Our Ref: R/41/18/HH
Your Ref:

Town & Country Planning Act 1990 (as amended)
Town & country Planning (Development Management Procedure) (England) Order 2015
Application for Planning Permission for Works or Extension to a Dwelling

Development Single storey rear extensions, canopy over alleyway & creation of first floor.
Location 30 Pigeonhouse Lane Rustington

DRAWING TITLE
Proposed Site Plan and Location Plan
PRELIMINARY

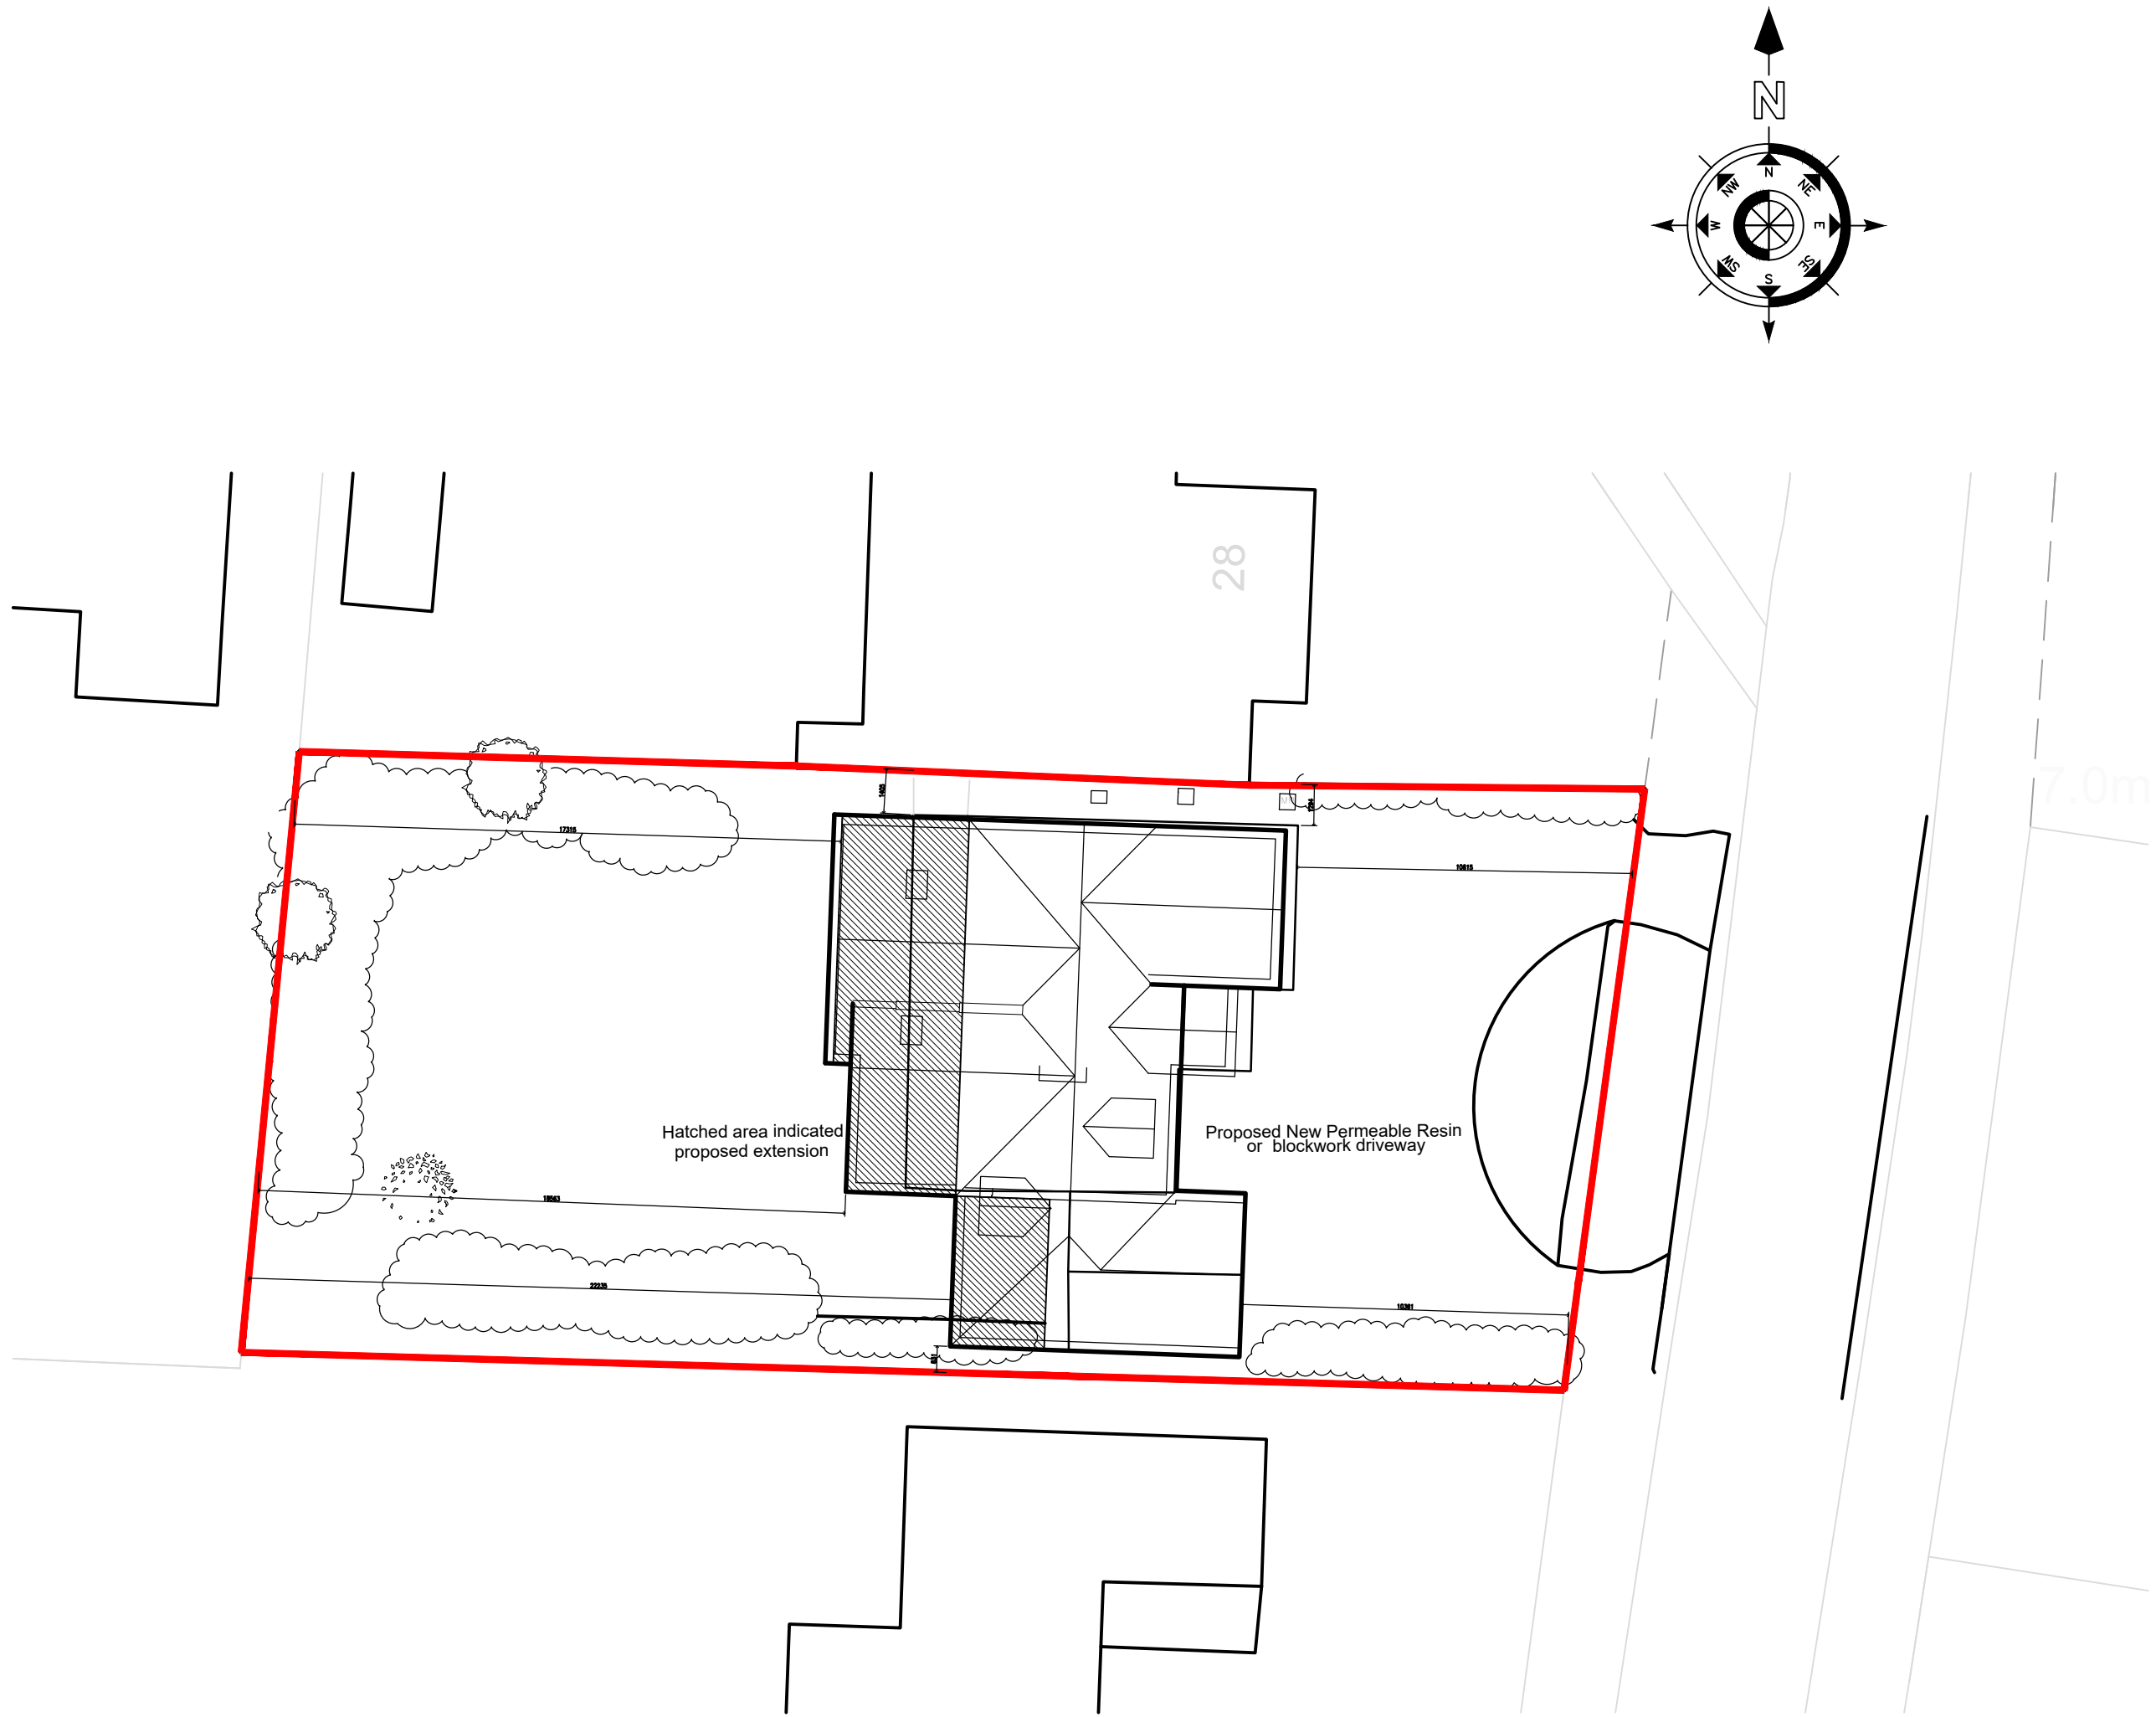
Block Plan Amend

Please submit 1 electronic or 3 paper copies of a block/site plan at a scale of 1:500 or 1:200. Further details of what must be included on the plan can be found in the National Validation Requirements. Please highlight the proposed works and provide measurements from the rear extensions to the site boundaries.
